WEST SUSSEX COUNTY COUNCIL CONSULTATION

TO:	Arun District Council FAO: Mr S Davis
FROM:	Highways, WSCC
DATE:	15/08/2018
LOCATION:	Land North of Sunnyside Cottages, Yapton Road, Barnham, PO22 0AZ
SUBJECT:	BN/22/18/PD Notification for Prior Approval under Class Q for a Proposed Change of Use of Agricultural Building to 2No. Dwellinghouses (Class C3) and associated works.
DATE OF SITE VISIT:	
RECOMMENDATION:	☒ Advice ☐ Objection ☐ Modification ☐ No Objection ☐ More Information ☐ Refusal
S106 CONTRIBUTION TOTAL:	£N/A

Block Plan

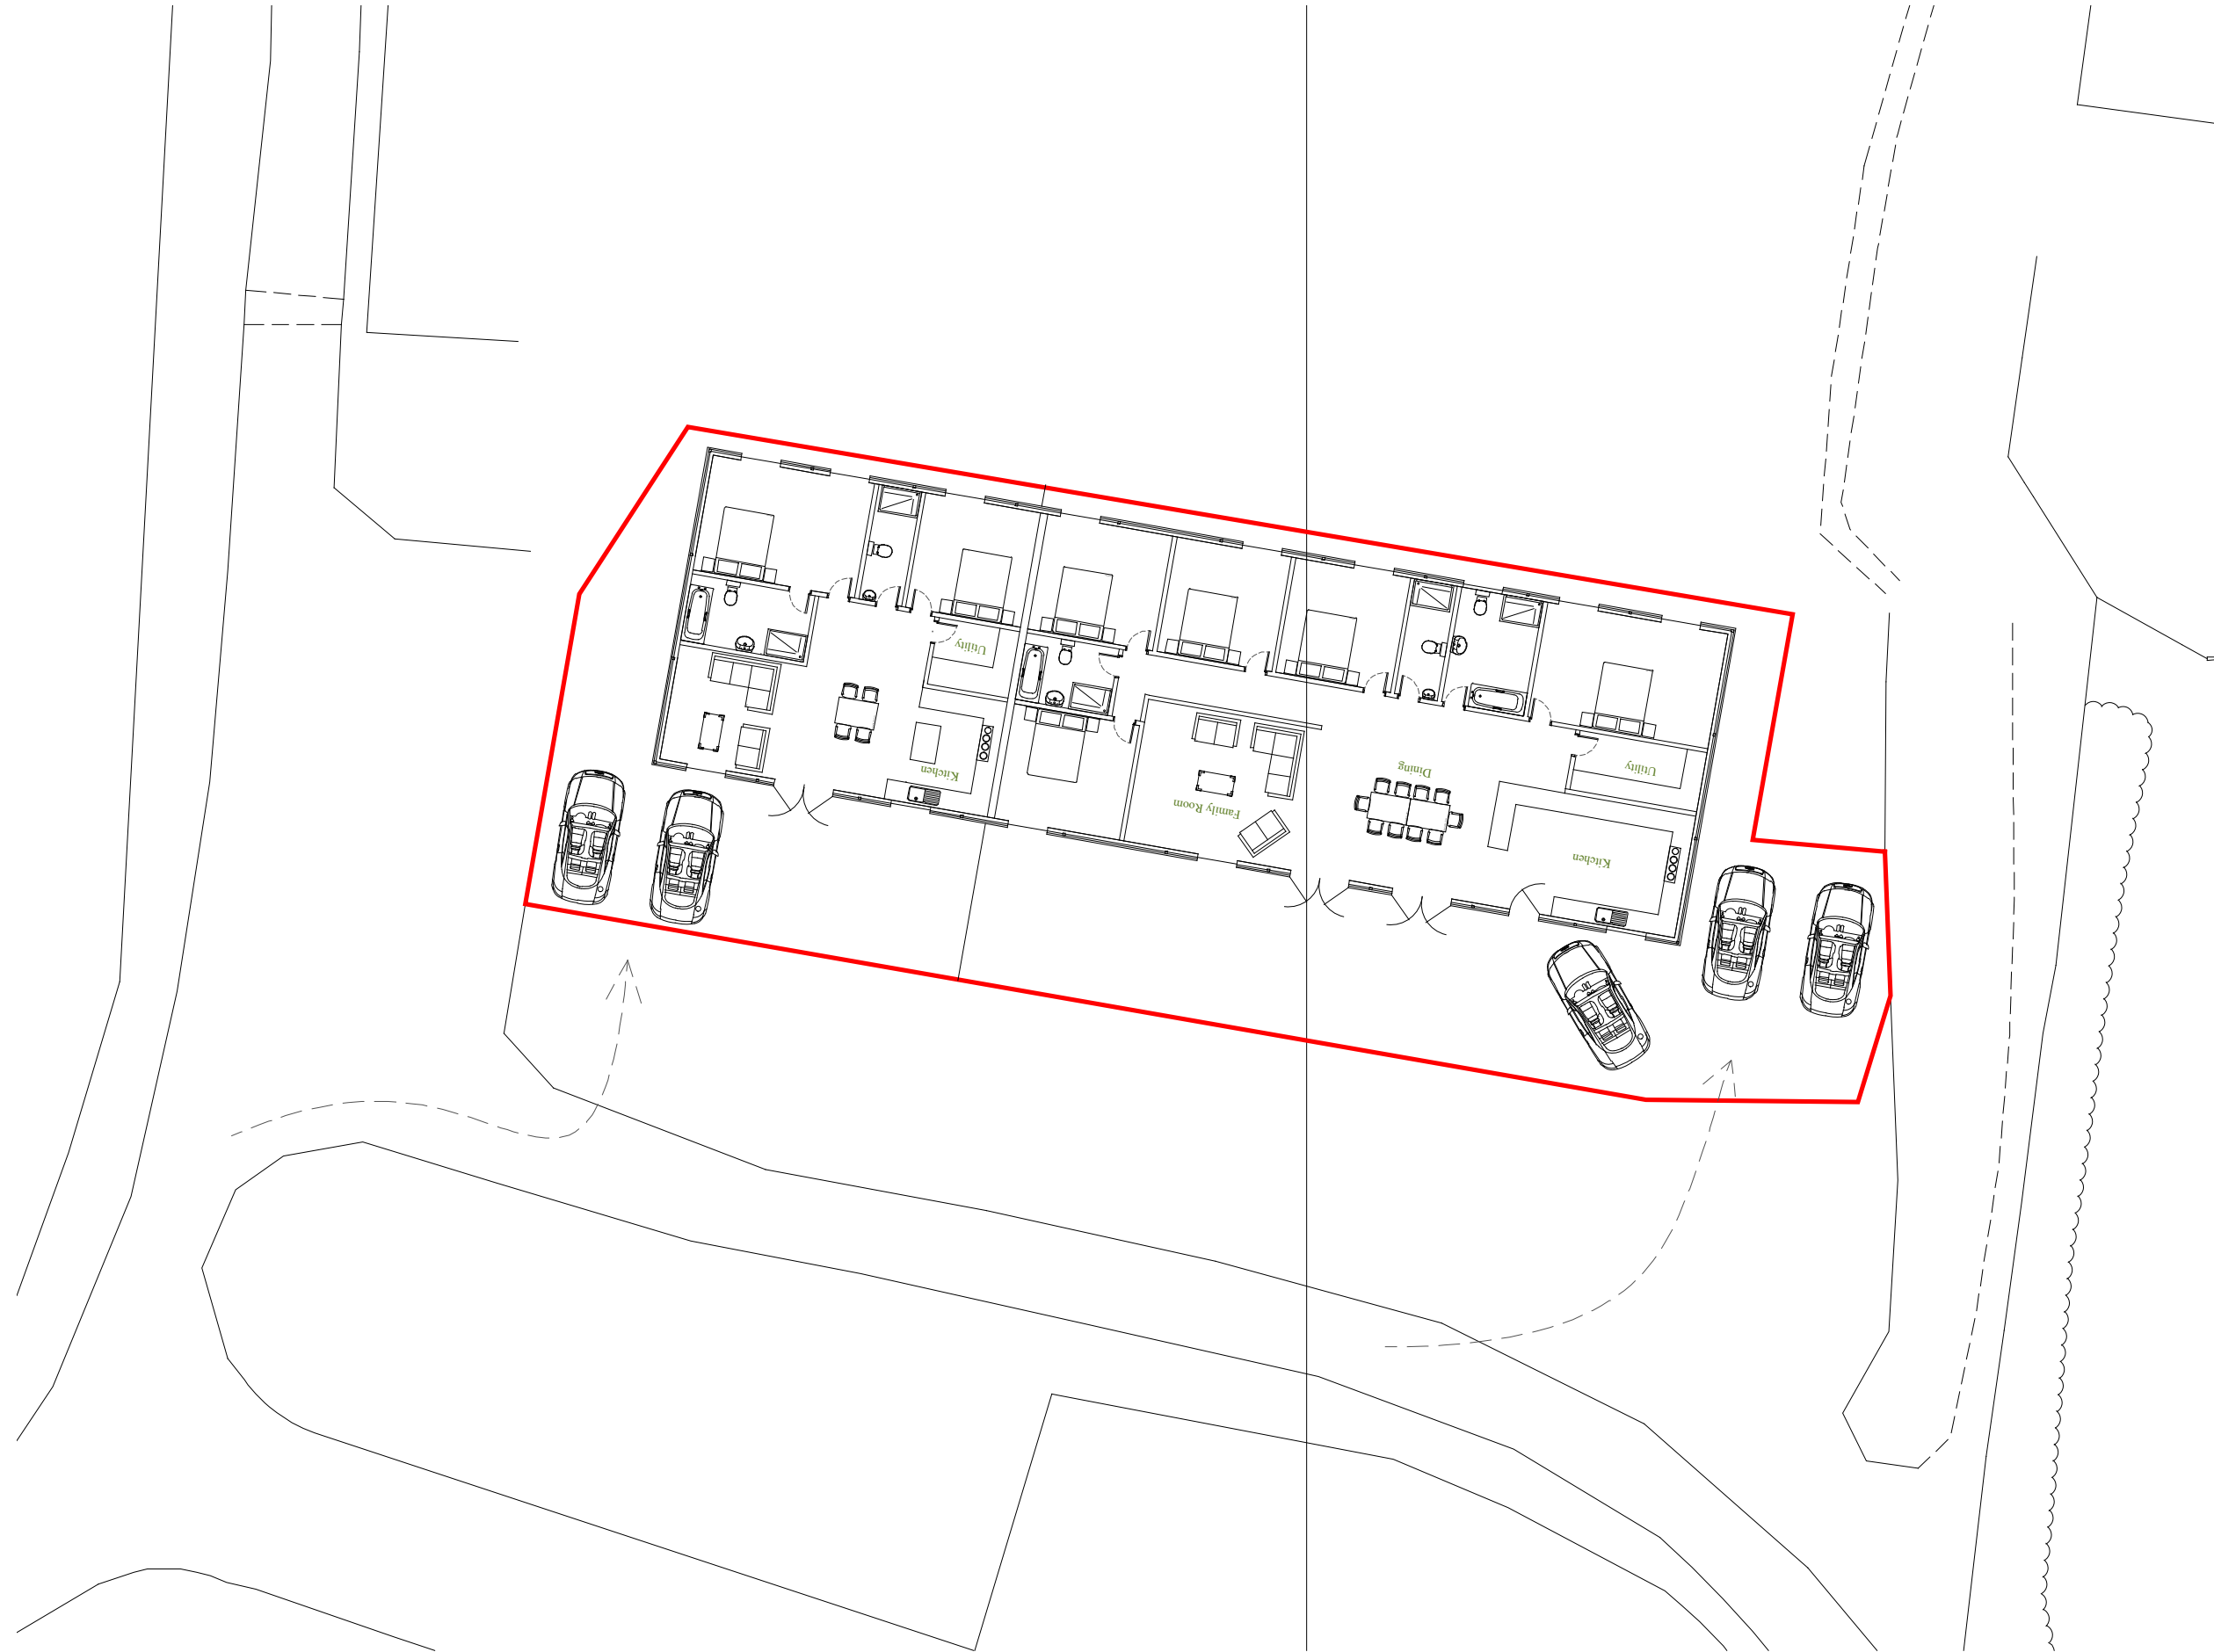
Vehicular parking spaces have not been demonstrated by the applicant however it appears that space would be available within the site to facilitate parking. Overflow parking would not be anticipated to occur on the Publicly Maintained Highway.
